Reference: 20240199-L02_response letter.docx

**RE: 59-63 TRAFALGAR AVENUE & 1A-B VALLEY ROAD, LINDFIELD
RESPONSE LETTER**

Please see below SGC response in **GREEN** to Ku-ring-gai Council RFI (SDD-79276958) dated 03/06/2025;

Project No.	Set No.	Drg No.	Revision No.
20240199	S01-SW302	B

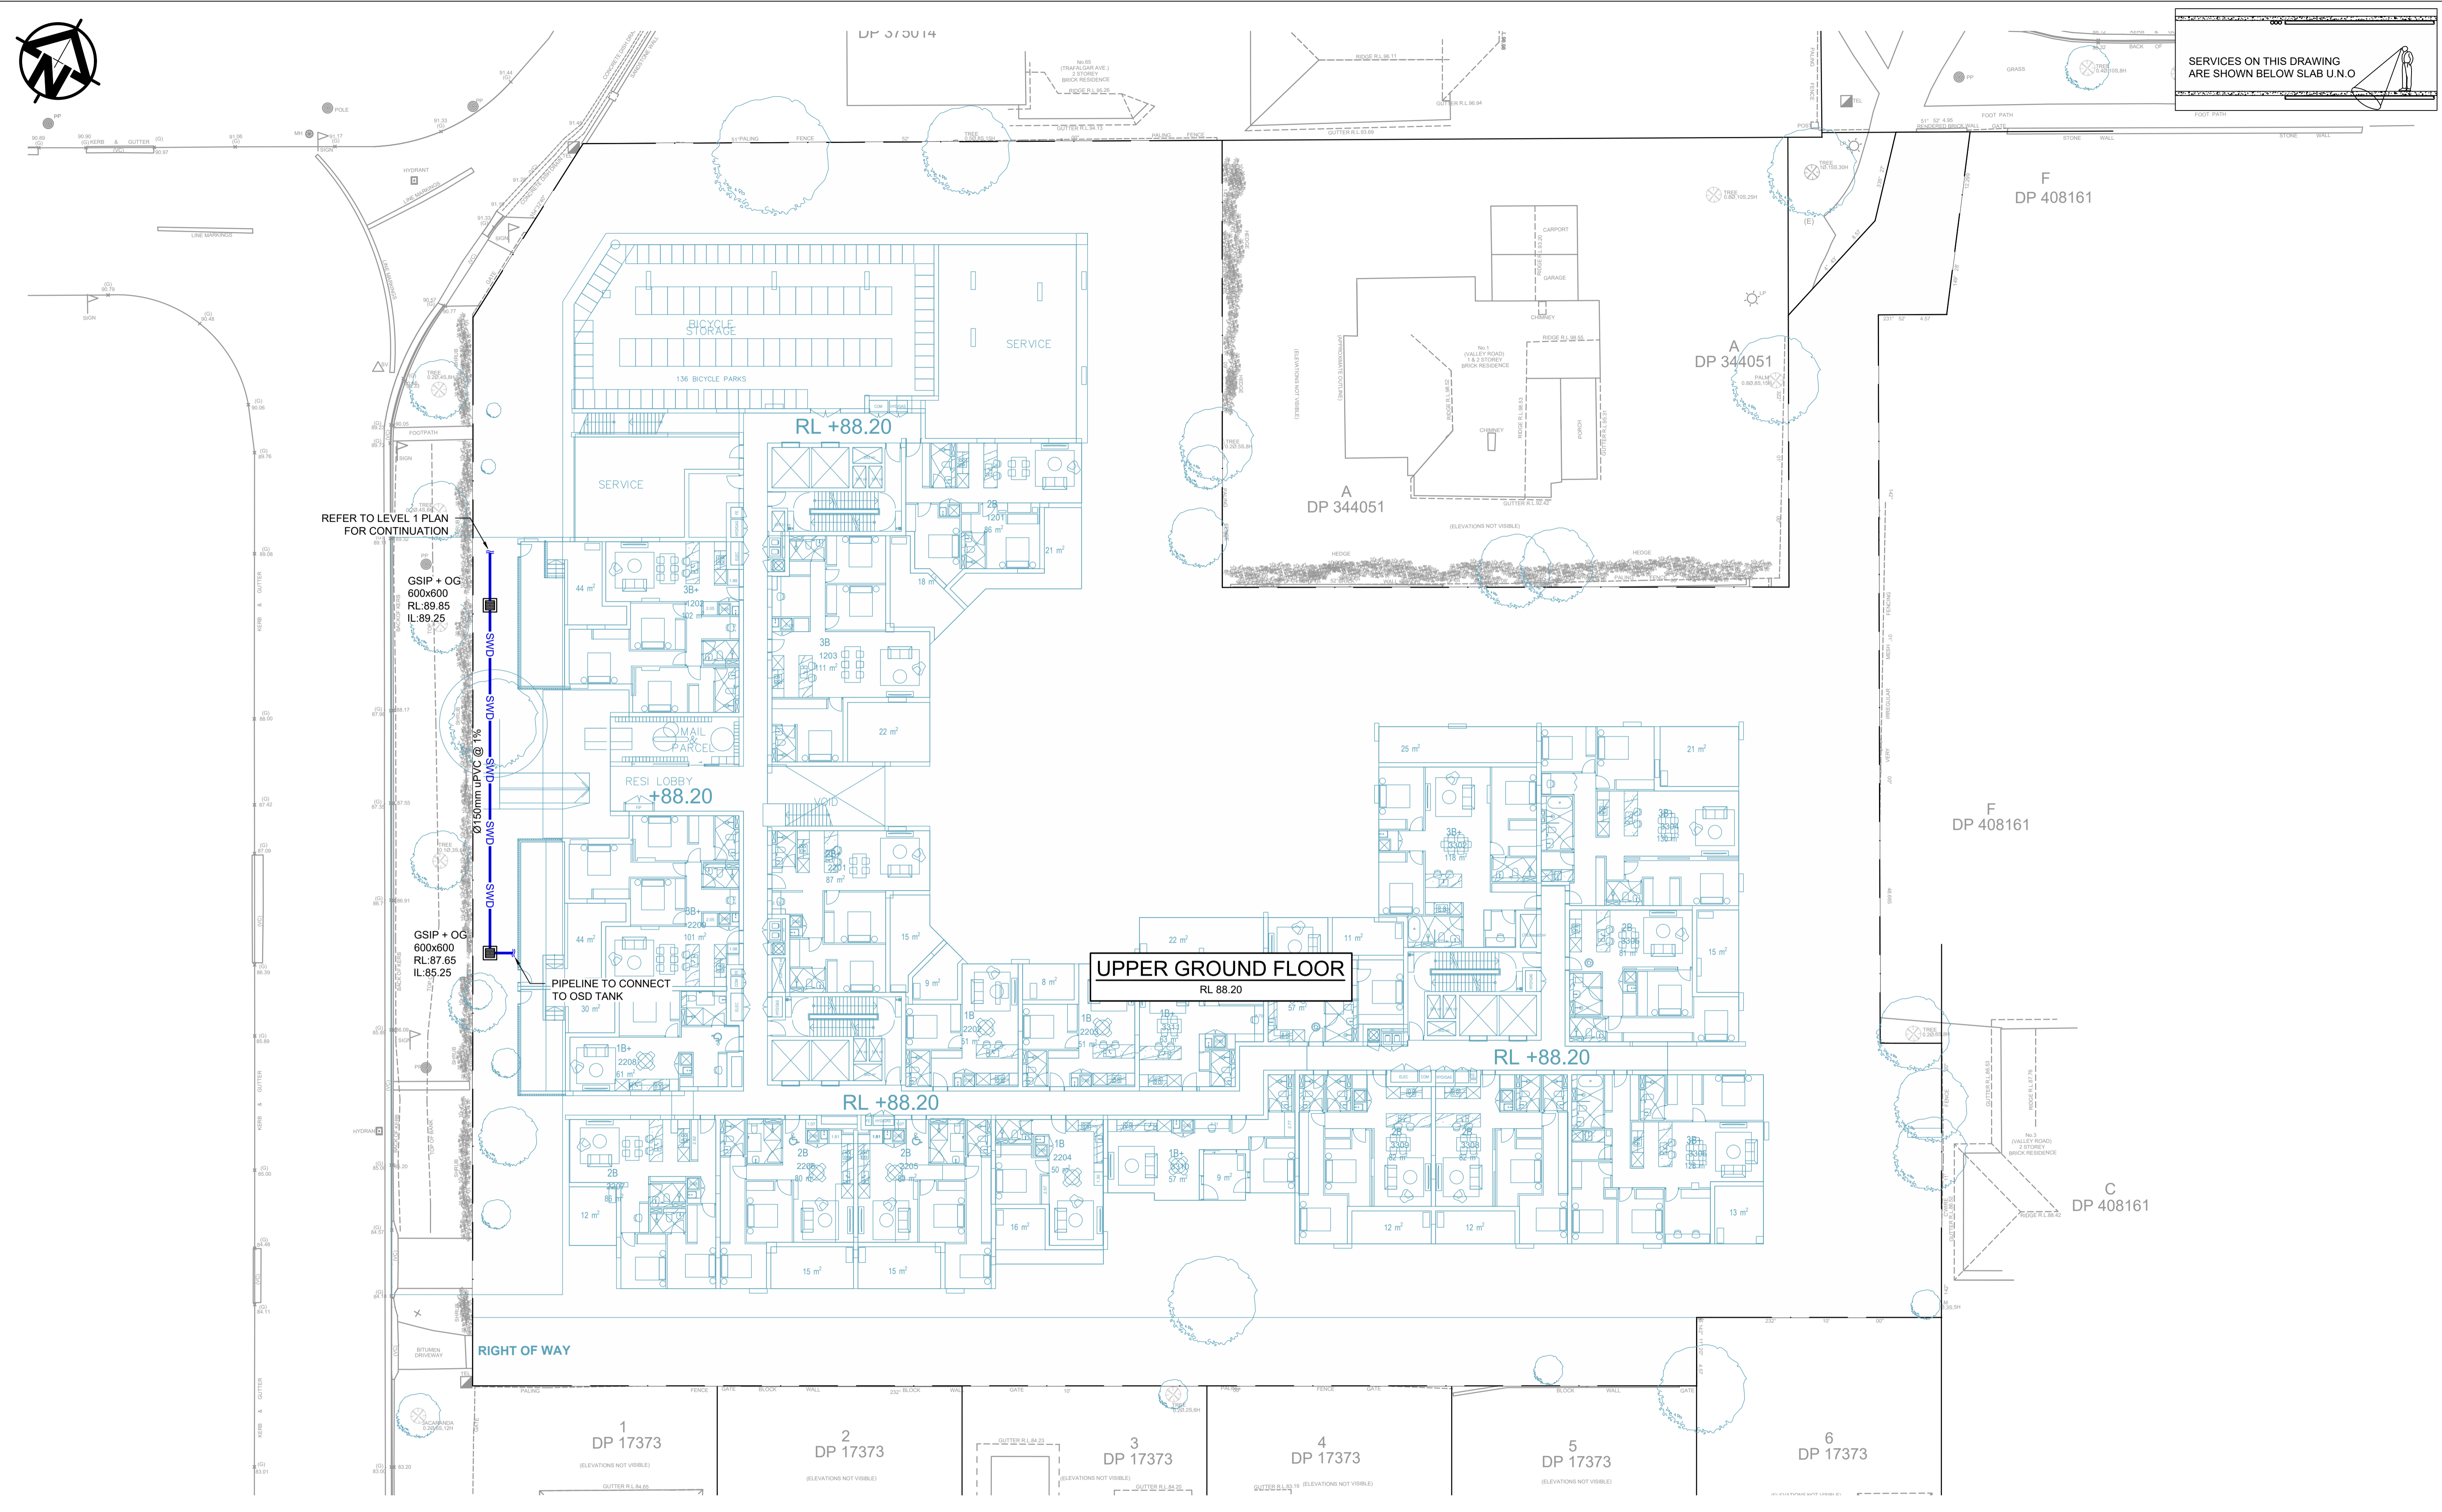
2. No supporting calculation for the pump-out pit based on the 100 year 2 hour storm has been submitted as per Part 24B.5 of the KDCP.

3. Stormwater design does not show the rising main from the pump-out tank directed to the on-site detention tank.

4. The location of the access pits to the detention system and rainwater tank are to be shown outside of the communal area (not within private courtyard).

SGC: The pump-out calculation has been incorporated in the stormwater plan.

SGC: The pump-out system connection into on-site detention tank has been denoted on the stormwater plan.

SGC: All access points into the Rainwater tank and On-site detention tank been placed in the common area.
